**Chapter V - Section 55
Subdivision Summary Form**

Meadowbrook Crossing

County: **EL PASO COUNTY**

# MEADOWBROOK CROSSING FILING NO. 1

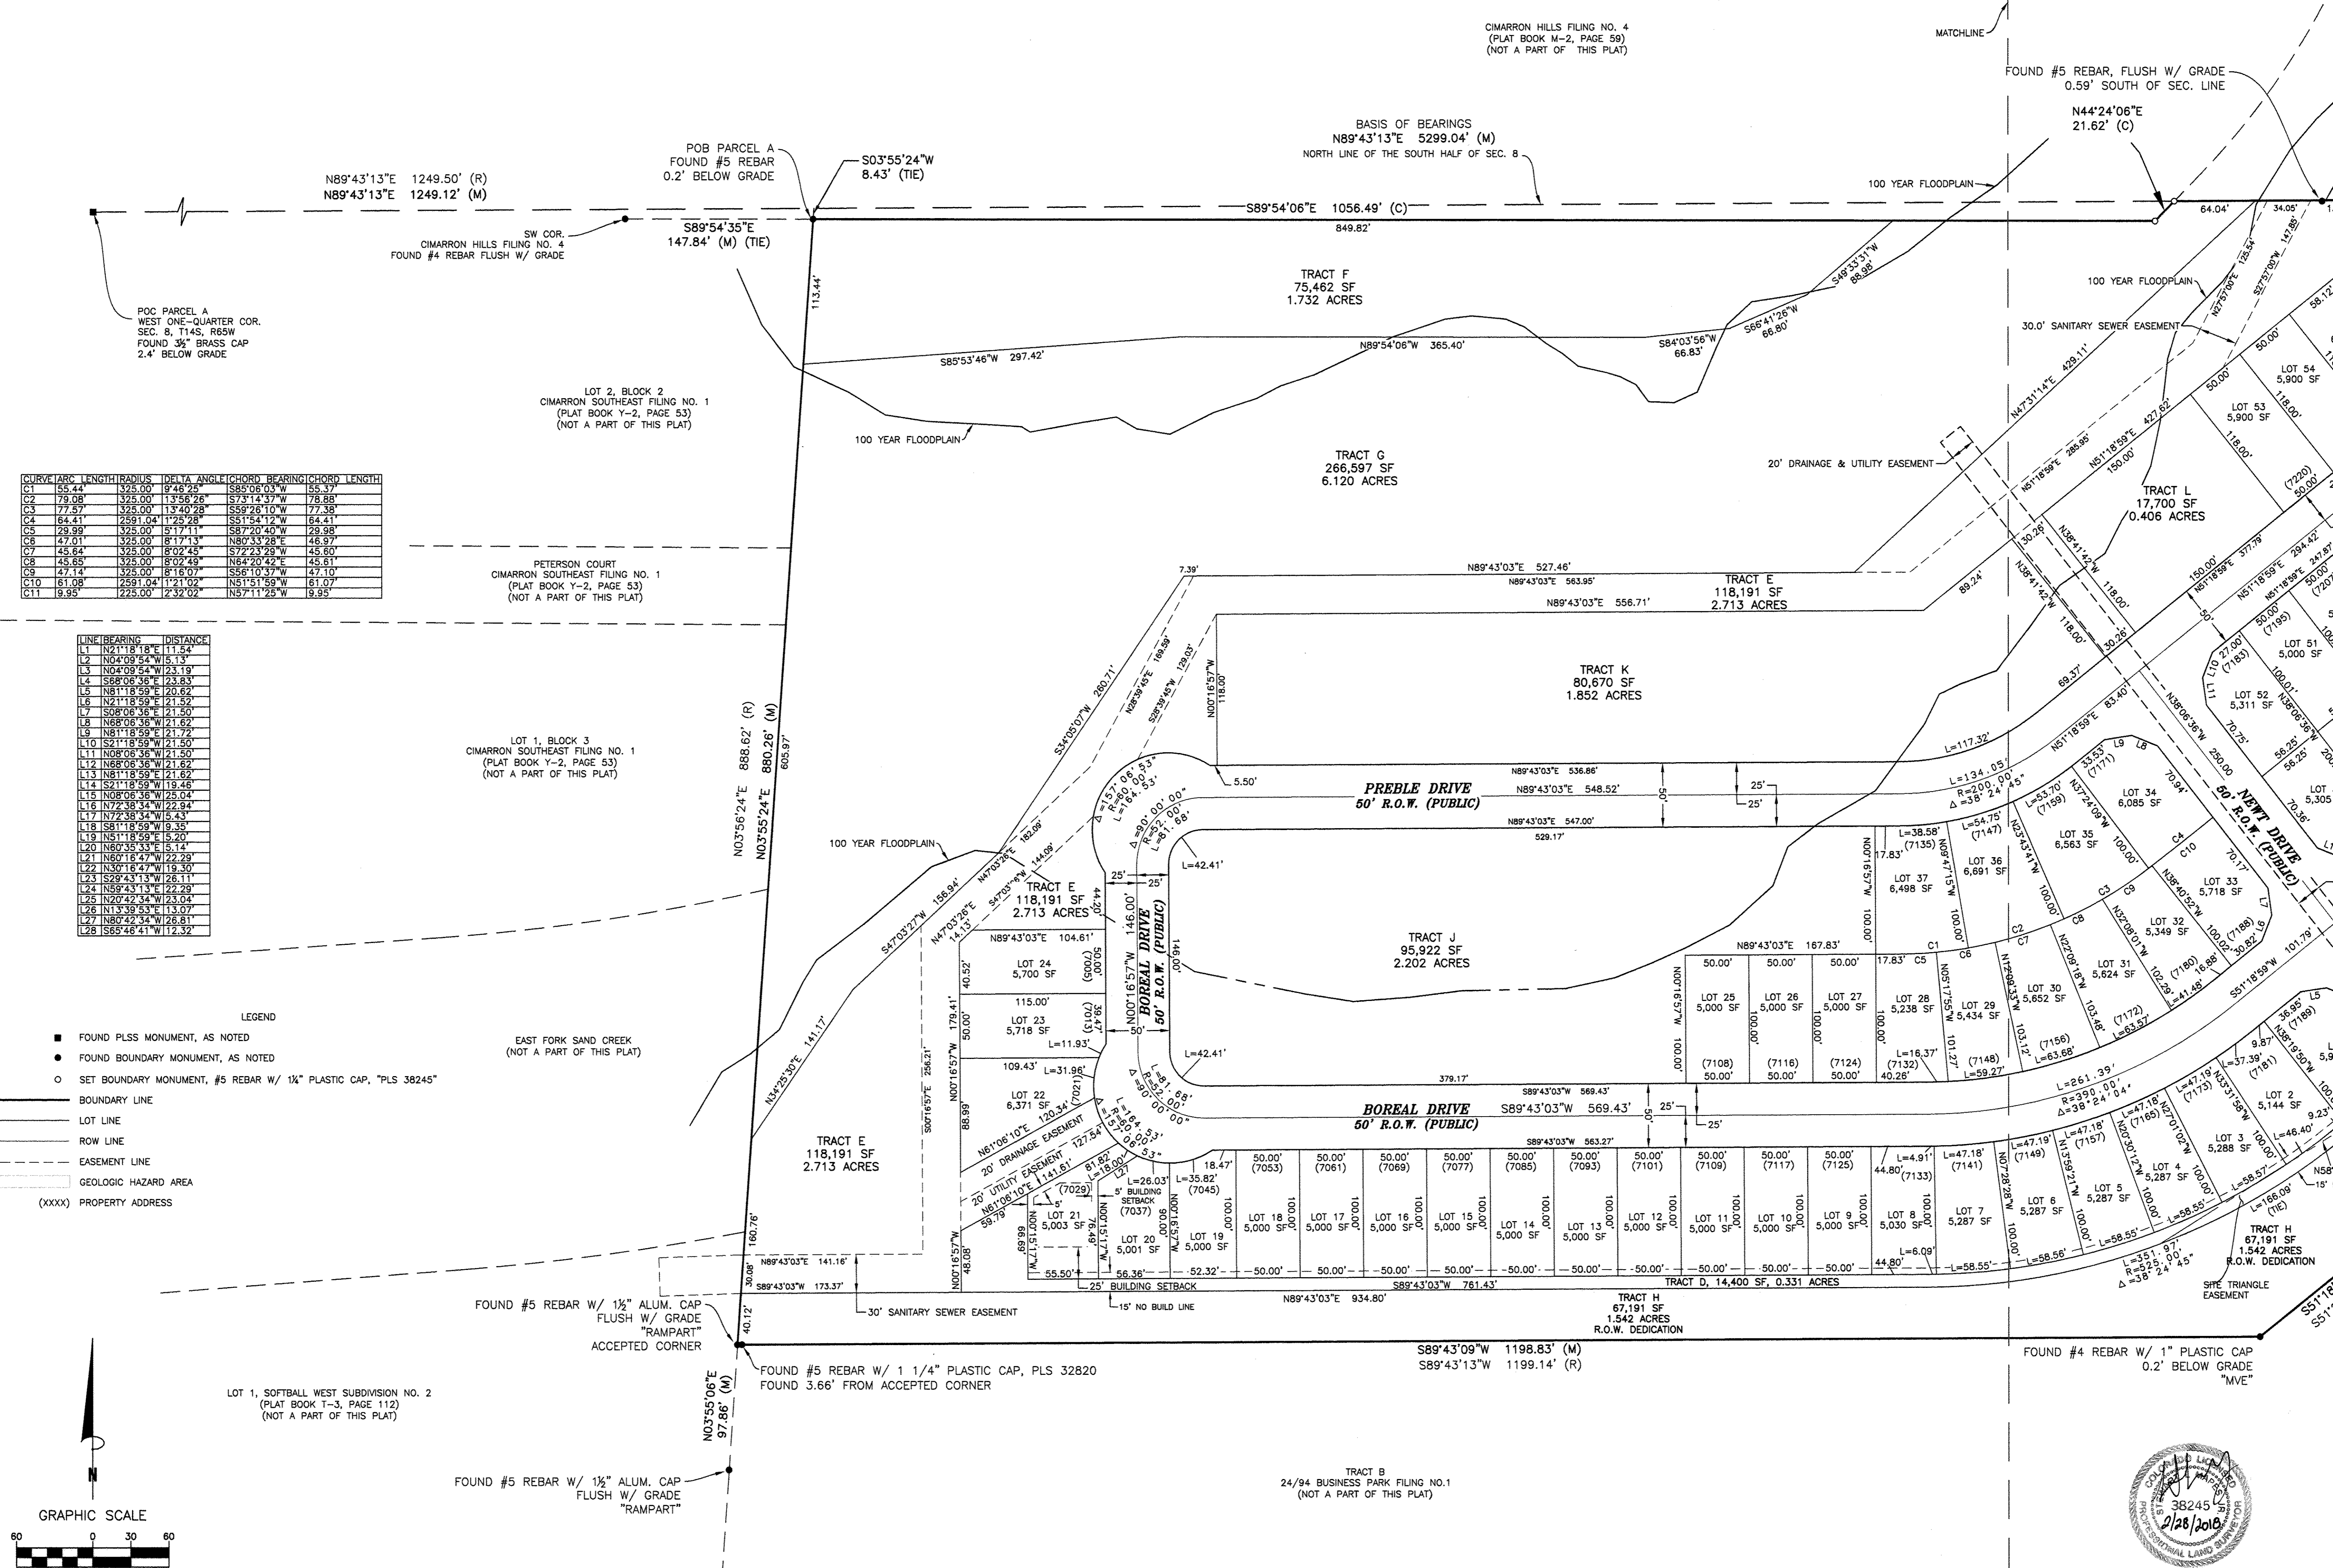
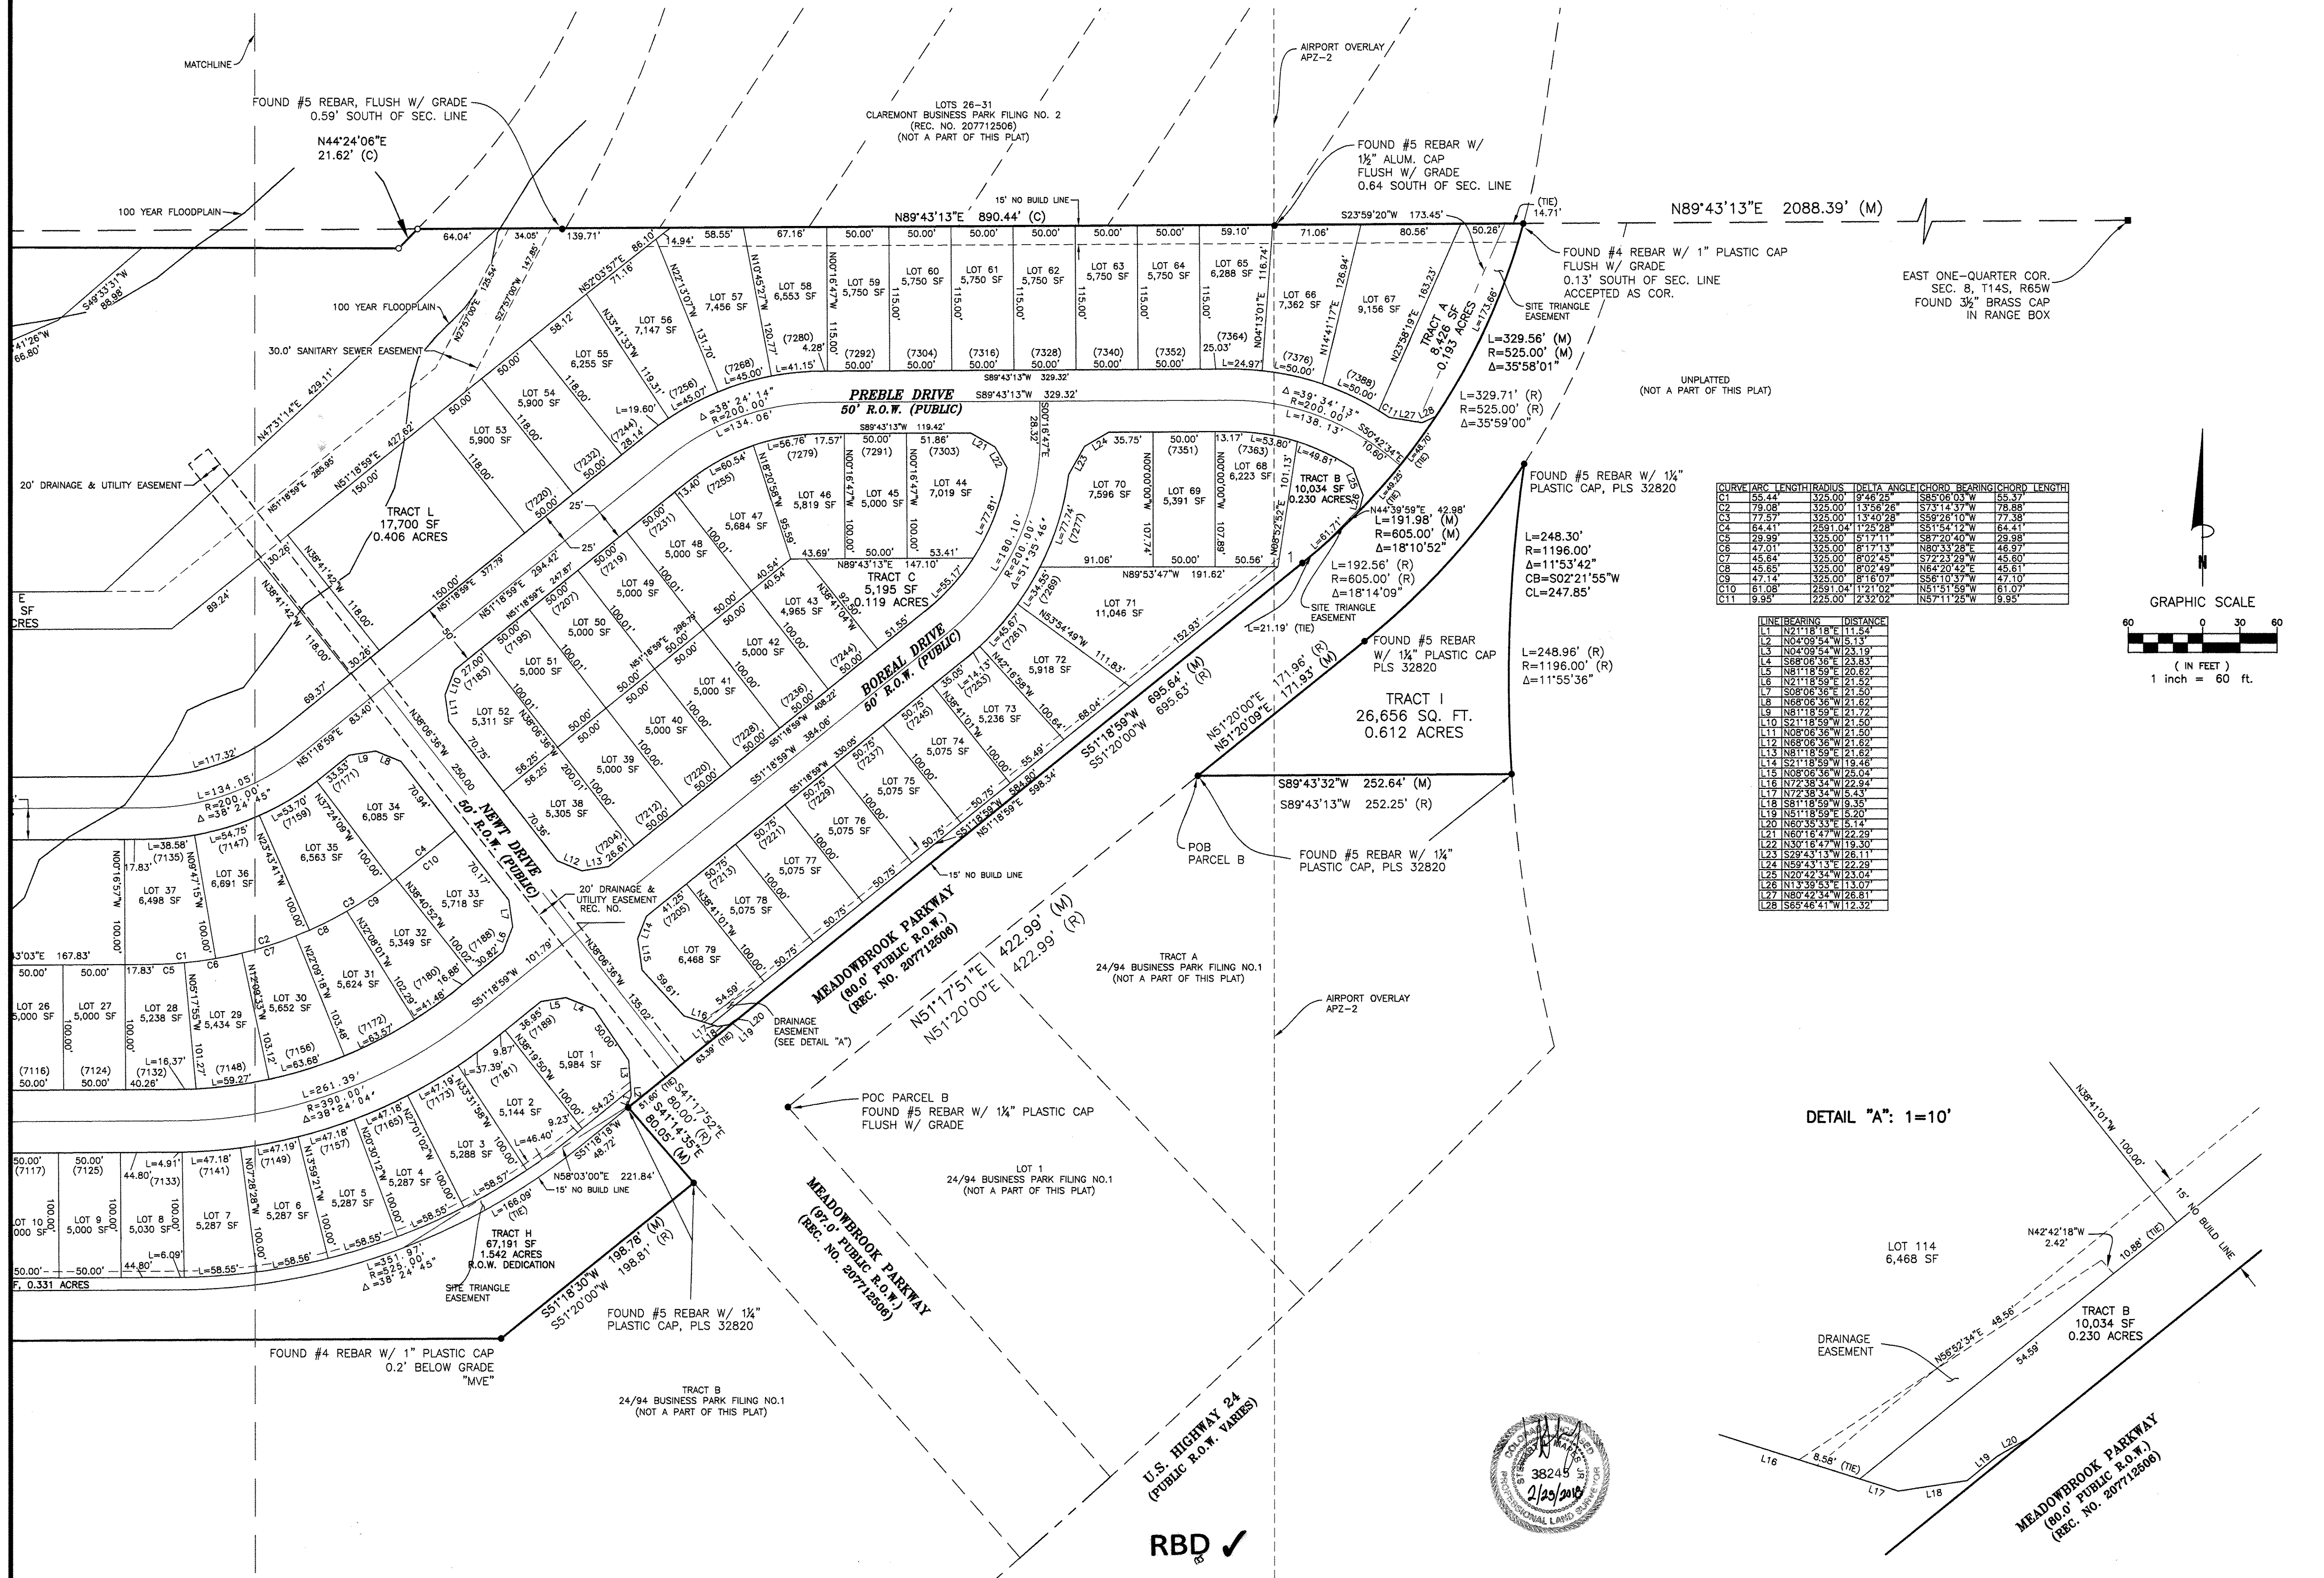
This should be reflected on the face of the plat in terms of totals. Legal should match.
